MMC: Congress/Gilman Streets Enabling Utility Work

We received the DPW Comments edited April 19, 2019 in the document titled "DPW_Congress St. Advance Work.pdf".

TITLE
**PLAN & PROFILE:
GILMAN STREET/
CONGRESS STREET
ENABLING WORK**

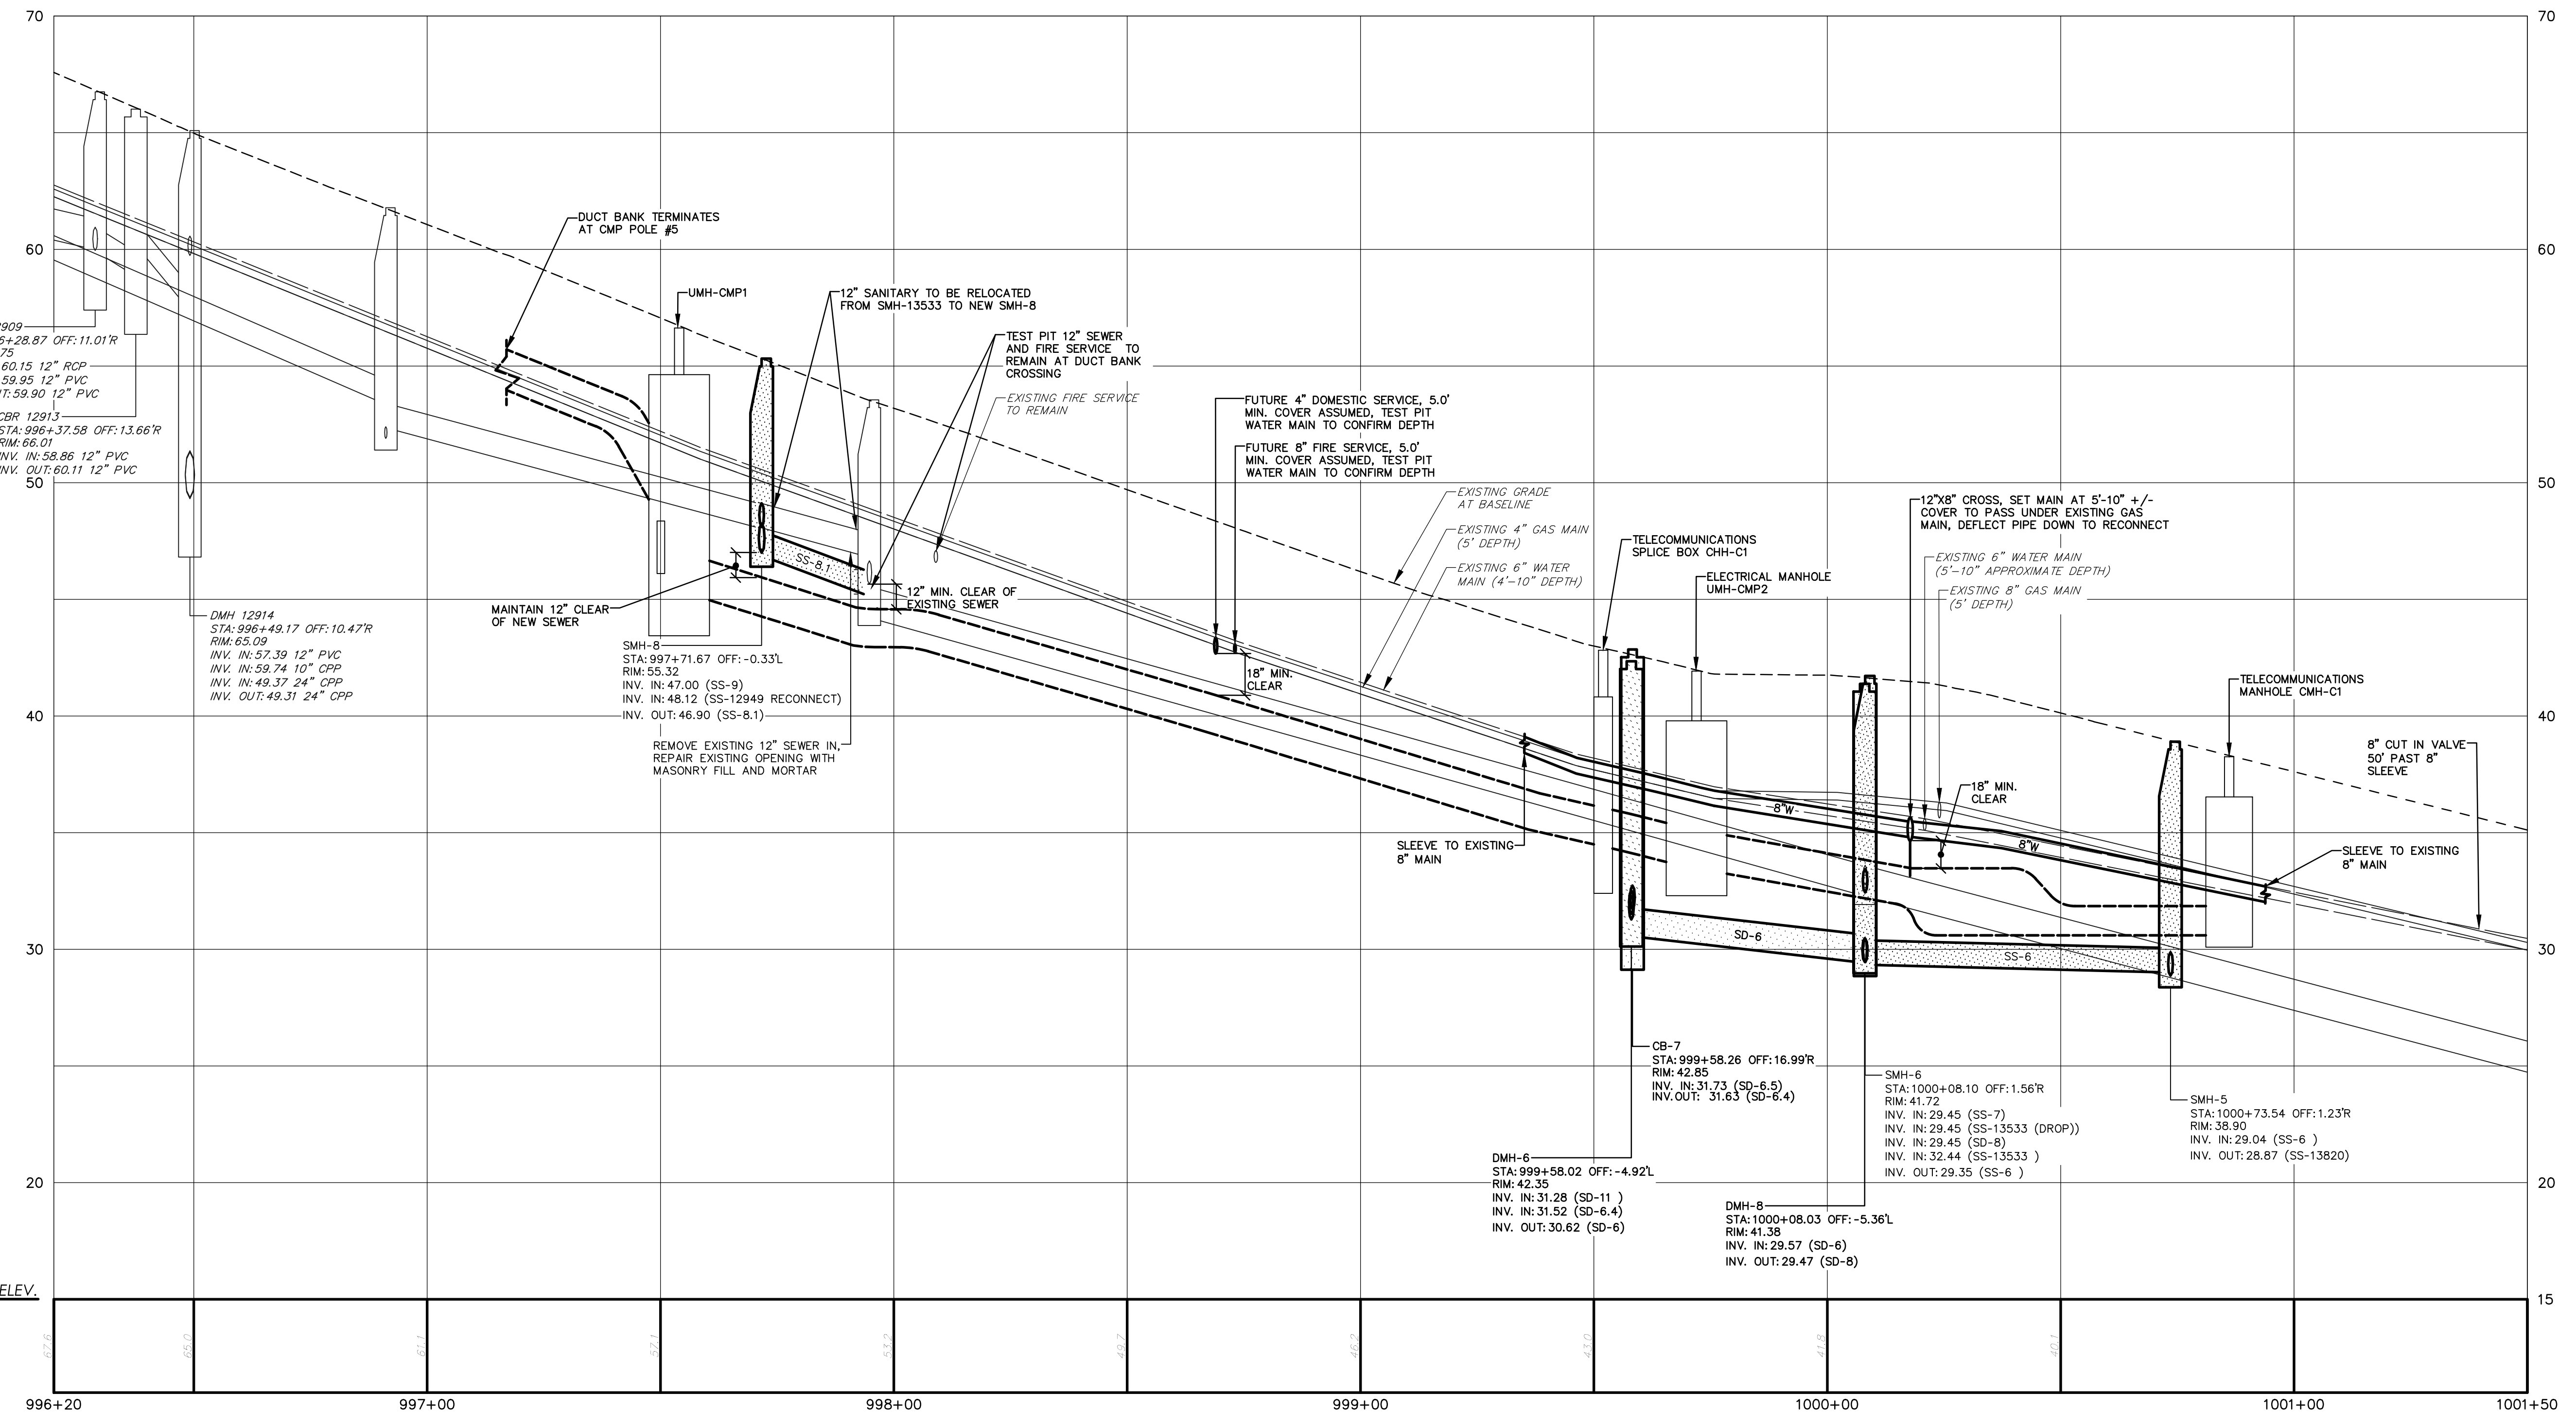
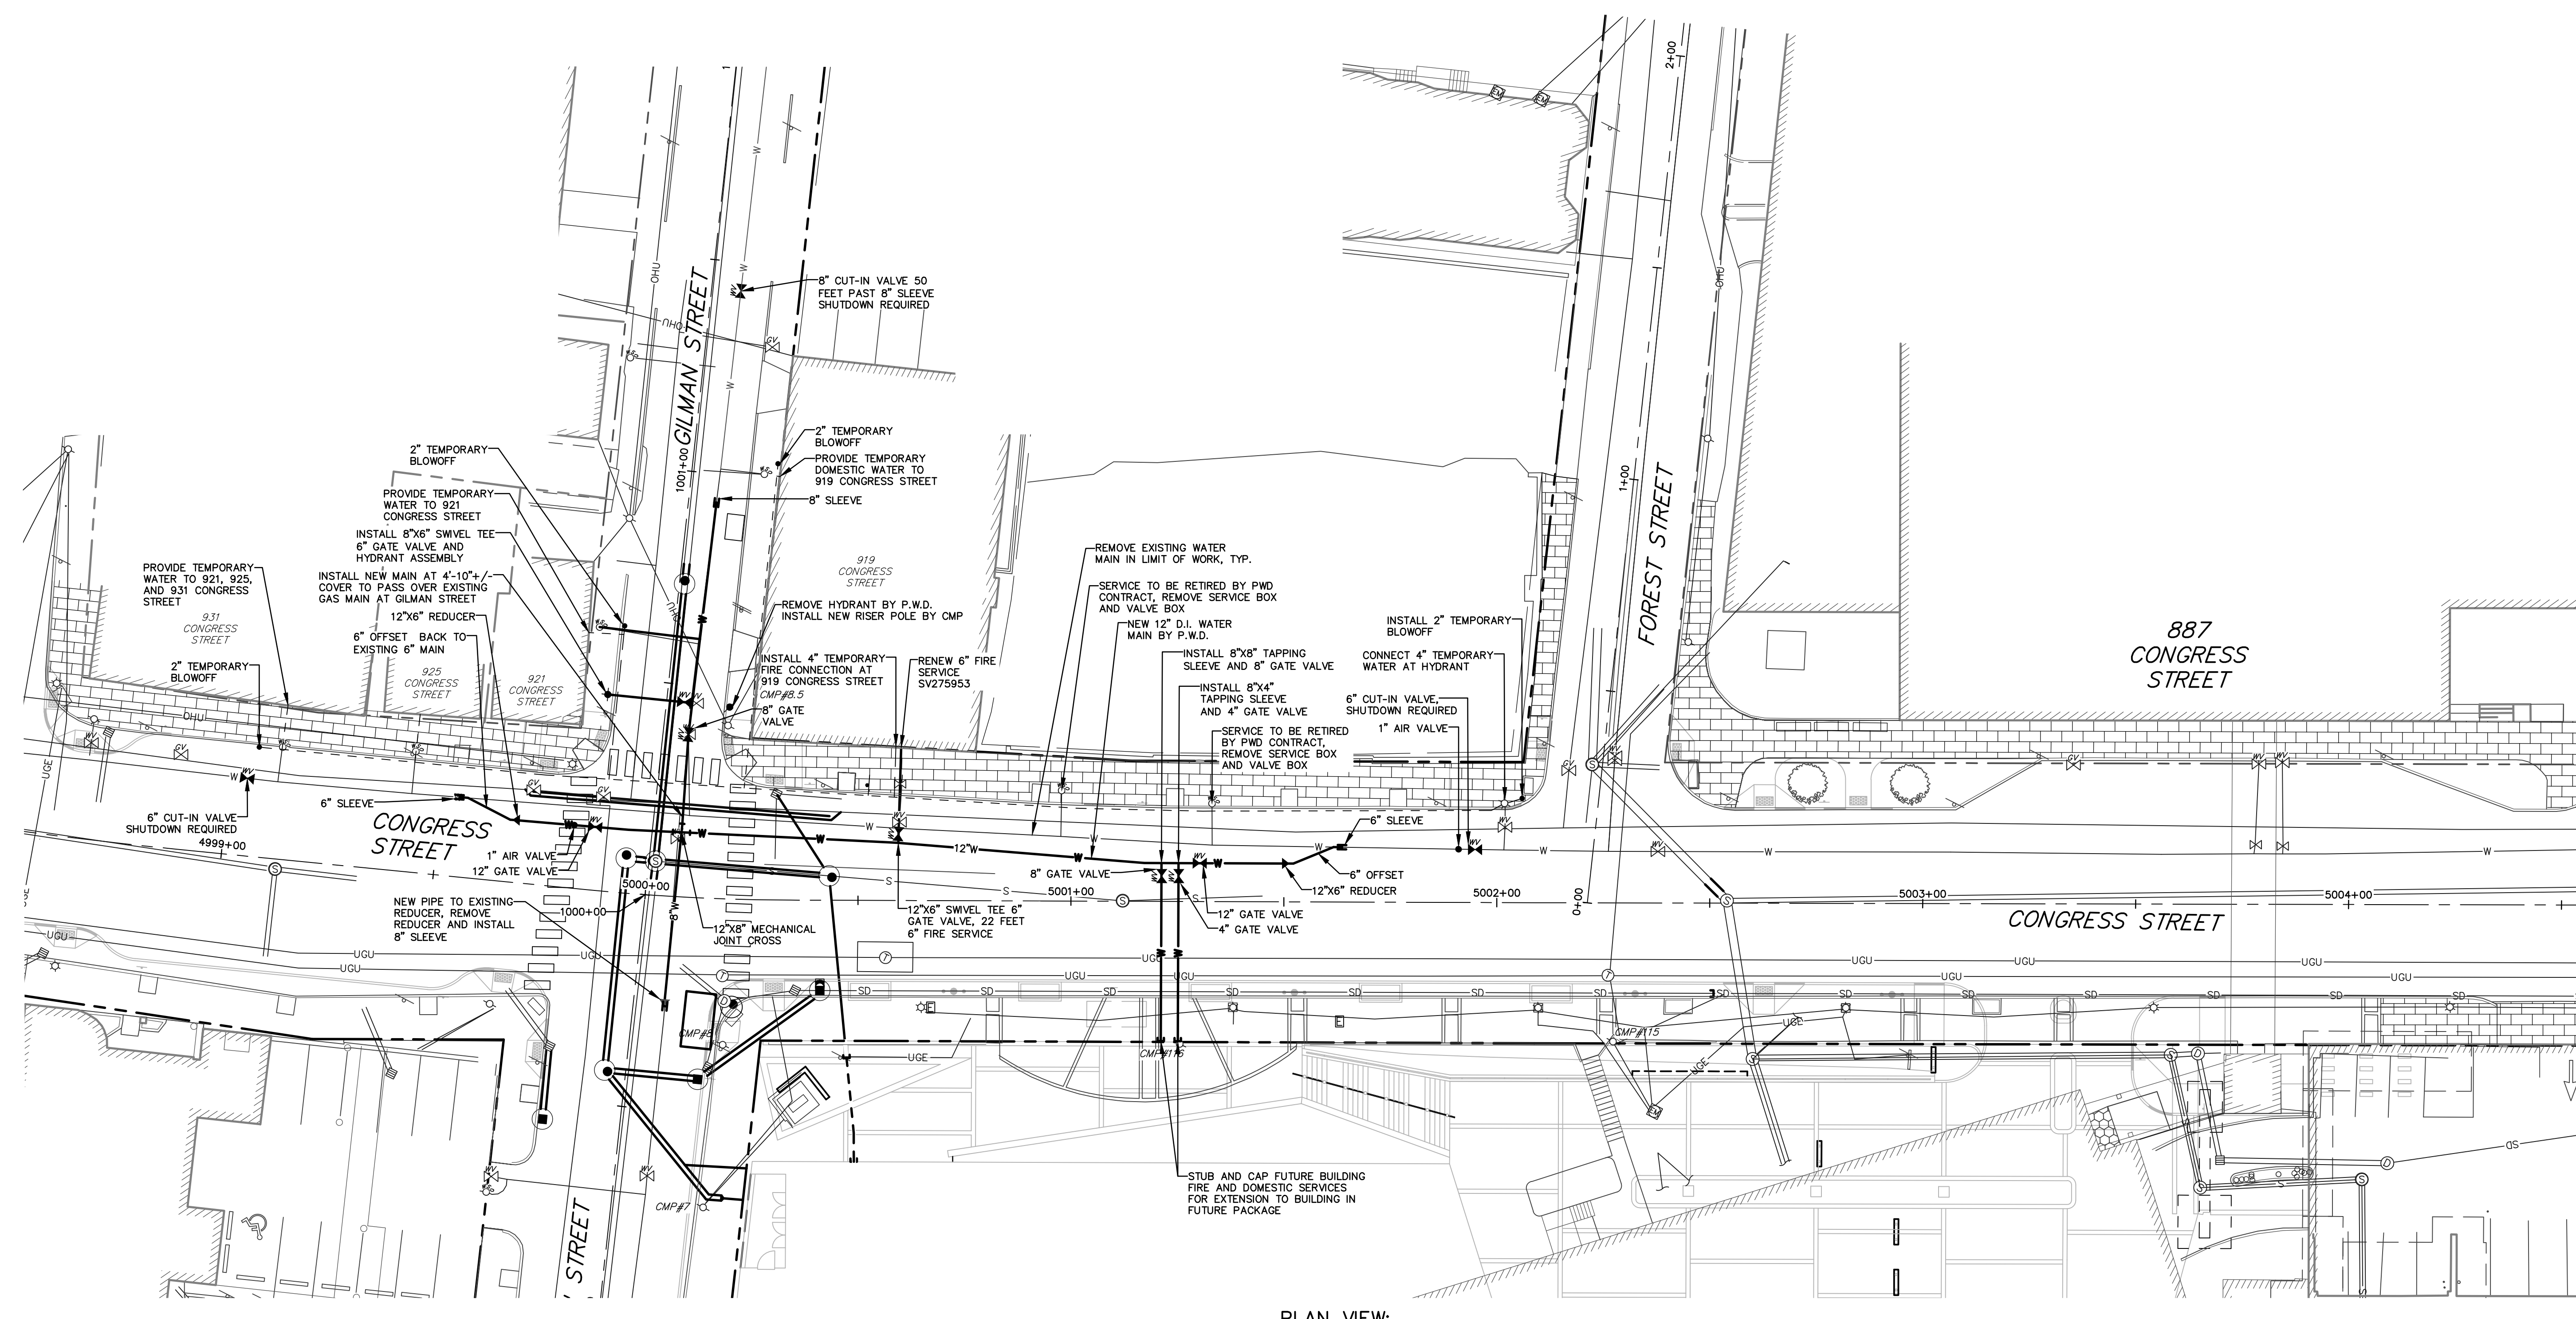
- Manholes and other structures located within the street should be placed as close to the centerline as possible, or aligned with the center of a vehicle travel lane, where at all possible. To the extent practical, proposed manholes should be shifted to align with these goals, possibly including, but not limited to, DMH-1, DMH-2, SMH-7, and SMH-8, all of which appear to be within the wheel path of a vehicle. Note that bicycle lanes should be kept clear of manholes where at all possible. DPW does not expect the applicant to make significant changes to the utility plan to accommodate this request; however, any minor adjustments that can be made will be advantageous to roadway conditions.

SMH-7 and SMH-8 are the two structures mentioned in the comments that are part of the enabling work. These new sewer manholes are located on the existing city sewer that is to remain. Relocating the structures is not possible without relocating the City sewer to a new location in the street. The manhole covers can be rotated to move cover as far as practicable out of the wheel path, but it is not practical to relocate the structures off of the existing sewer location.
